Memorandum

Dakota Springs Engineering

Subject: Springs at Waterview Rezone
P-17-017

The purpose of this memorandum is to provide a response to the comments received in your letter of January 25, 2018. Below is your comment followed by our response in *italics*.

# SPRINGS AT WATERVIEW ZONING MAP

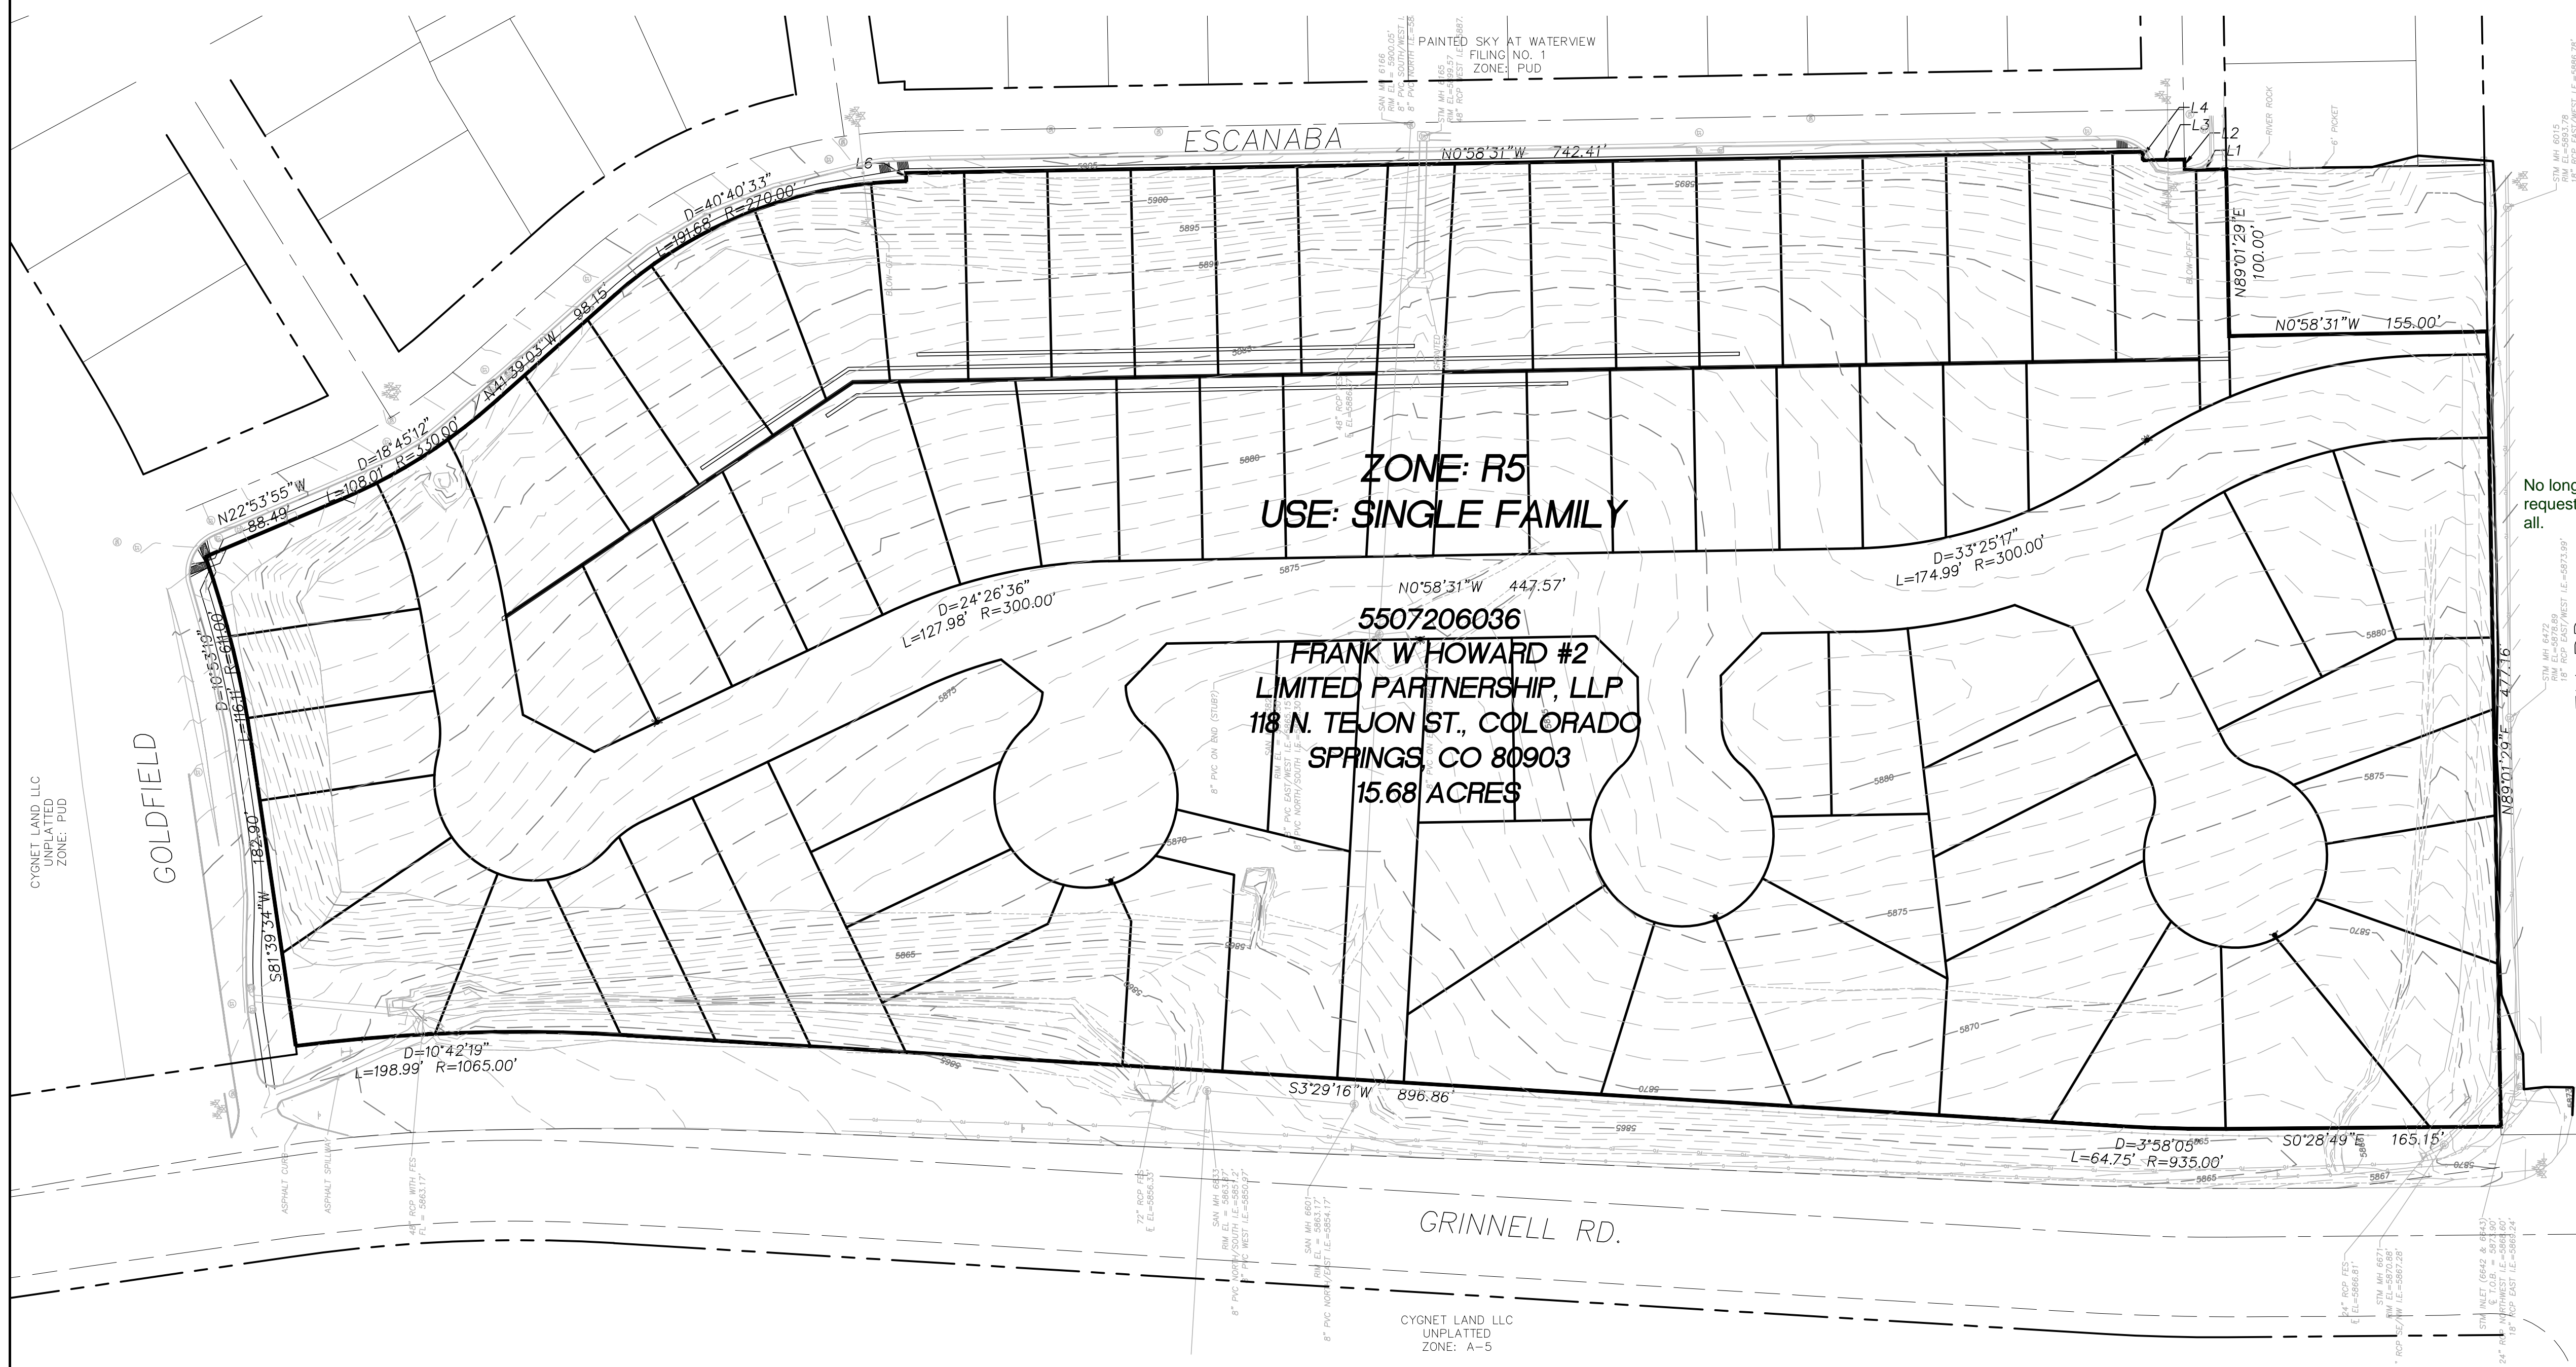
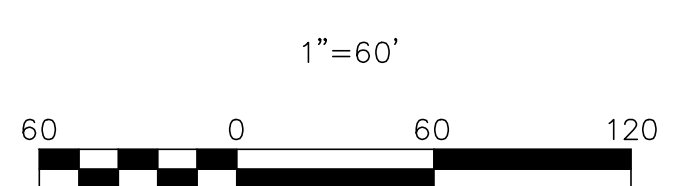
Zoning Map 1. Please review the zoning map checklist and add all required information. The drawing submitted is for a PUD, not for conventional zoning.

Done
